**The Morecambe Offshore Windfarm Generation Assets Development Consent Order
Application**

**Deadline 3 submission by Spirit Energy Production UK Limited
Response to the Applicant's Deadline 2 Submissions**

**EN010121
Unique Reference: 20049981**

Date	22 January 2025
-------------	-----------------

Figure 4.2 AW169 One Engine Inoperative Continued Take-off Profile

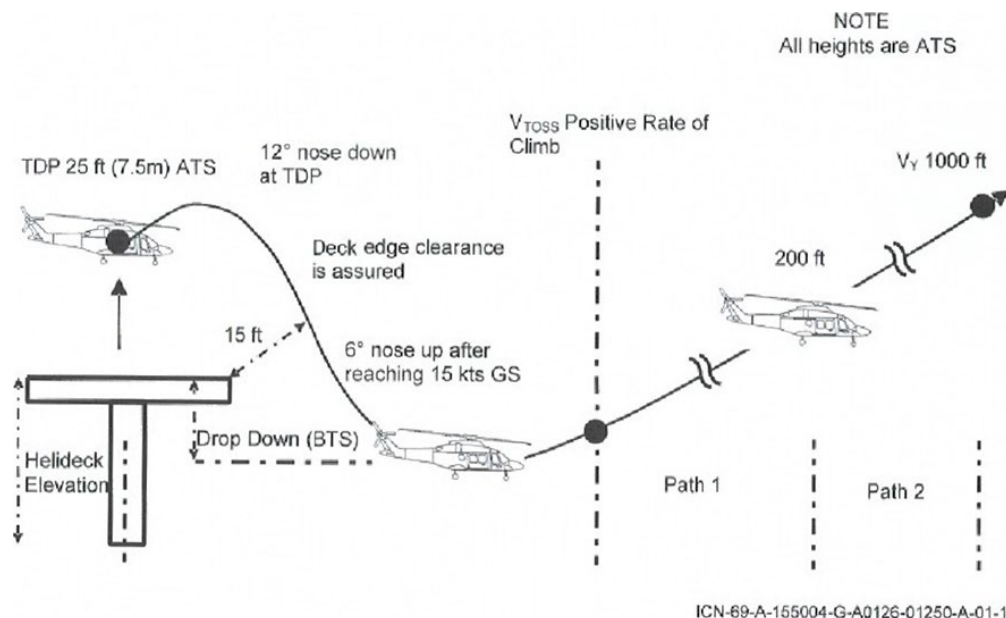
- 3.8 The full calculation of the 3.9nm requirement is provided in the Aviateq Report at Section 9.6 but is also set out in Appendix 4 of this submission. In summary the 3.9nm distance comprises the following elements.

- 3.9 The distance required to safely execute take off on one engine is:
- 3.9.1 Section 1: Acceleration from TDP to Vtoss and positive ROC (CTO): Distance required 0.19nm

- 3.9.2 Section 2: Path 1 Climb from end of CTO to 200ft: Distance required is 0.16n
 - 3.9.3 Section 3: Level Acceleration from Vtoss to Vy at 200': Distance required = 660m or 0.36nm (Graph S4-32.)

- 3.9.4 Section 4: Path 2 climb from 200ft to 1000ft: Distance travelled is 1.80nm (S4-9 and S4-43)
- 3.10 The total distance required for OEI TDP to 1000ft would be the sum of the 4 sections namely 0.19nm + 0.16nm + 0.36nm + 1.80nm = 2.51nm.

- 3.11 Then, 0.35nm distance is added to accommodate a situation that may arise necessitating a 180 turn away from the obstacle - Rate One Turn at 1000 ft (IFR) taking the required distance to 2.86 nm.

- 3.12 Then the legal obstacle clearance requirement of 1nm is added, taking the total minimum distance requirement to 3.86nm.
- 3.13 The Applicant is stating the calculation of 3.9nm is incorrect based on certain assumptions. Spirit's view on each of the points is as following:

- 3.13.1 That there has been a drag factor applied on flight path 1: a drag factor is applied as the aircraft has a fixed undercarriage.
 - 3.13.2 The Applicant is stating that the maximum aircraft mass of 4,800kg should be reduced to allow for fuel burn-off as the flight progresses. This completely disregards operational requirements for efficient offshore NUI shuttling whereby any fuel burn-off is then re-loaded with extra passengers or baggage on CPC. In short, 4,800kg is available as the permitted payload and any reduction in weight for fuel can be utilised for a multitude of other purposes. For the foregoing reasons, the 4,800kg is the appropriate (indeed only) reasonable worst case assumption that can be used. Spirit must ensure safe operations at the maximum take-off weight of 4,800kg.

- 3.13.3 The Applicant has stated that Aviateq should calculate the climb to 1000ft during Section 2 of the calculation above from Above Mean Sea Level (MSL) instead of Above Take-off Surface (ATS). The Applicant (and AviateQ) acknowledge that this statement is correct and are content for this assumption to be applied. Aviateq have re-calculated the distance for Section 2 in line with this requirement, reducing this part of the calculation by 0.1nm.

- 3.14 On this basis Spirit is willing to work with the Applicant to agree a protection that reduces the 3.9nm requirement to a 3.76nm unobstructed airspace requirement between the extremity of the Aviation Affected Assets and the Unconstrained Areas.

Figure 7.4 Take-off Corridor for CPC-1. Wind Direction 220° with 1nm Lateral Buffer

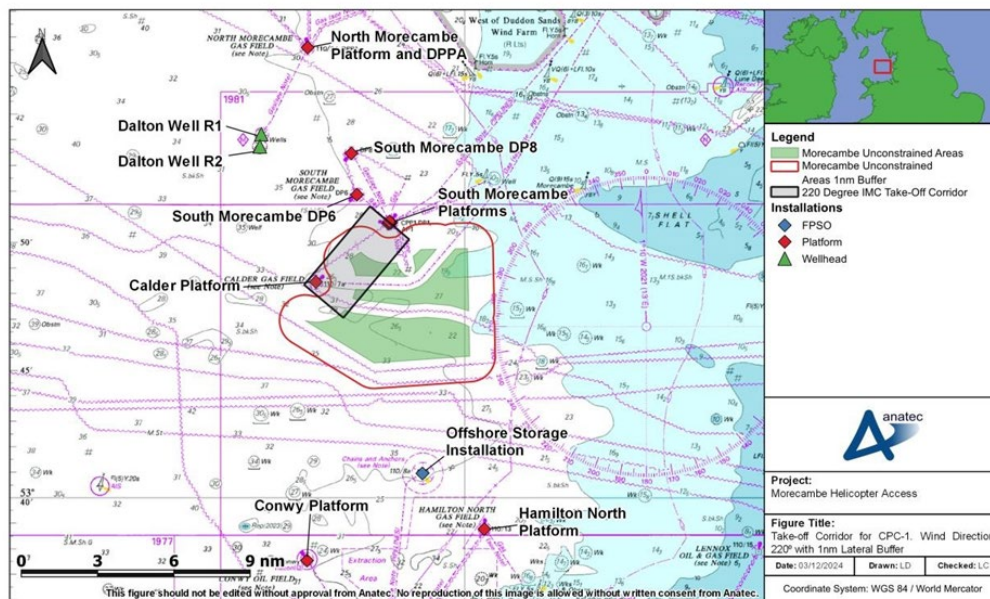
- 3.18 The Applicant has proposed a new 2nm wide x 4nm length take-off access corridor orientated into the prevailing wind, which is principally described in Appendix B: Helicopter Access IMC Corridor - Revision 01 (Volume 9) [REP2-030]. This section comprises Spirit's response to this proposal.

- 3.19 The IMC Take-Off Corridor proposed by the Applicant in section 5 of the Applicant's Response to Spirit Energy Deadline 1 Submissions [REP-030] fails to meet Spirit's requirement for a 3.9 nm buffer around the full 360 degrees of CPC, DP6 and Calder; any less (with the exception of the potential reduction to 3.76nm previously acknowledged) will have unacceptable impacts on the safety of Spirit's operations.

- 3.20 Spirit cannot accept the IMC Take-Off Corridor as it will only mitigate instances when the wind is coming from the corridor direction towards CPC. As per GM1 CAT.POL.H.310(c) & CAT.POL.H.325(c) (Take-off and landing) regulations, under normal operations the aircraft should approach and take off into the wind (head wind). The MetOcean criteria data analysis outlines that only 22% of wind comes from the direction of the corridor proposed. The Applicant has failed to demonstrate how this applies to landing at CPC and take off in the remaining 78% when the wind is not from this direction, or how it meaningfully mitigates take-offs and landings at all from Calder or DP6.

- 3.21 Under the new proposed CAA regulations, the IMC corridor proposal will not be able to provide any mitigation for IMC take-off and landing to/from CPC, DP6 and Calder platform in both day and night conditions or for VMC take off and landings to/from CPC, DP6 and Calder Platform in night conditions without a CAA dispensation under the Alternative Means of Compliance (AltMoc) process. Spirit is not aware of such AltMoc being granted elsewhere in the UK.
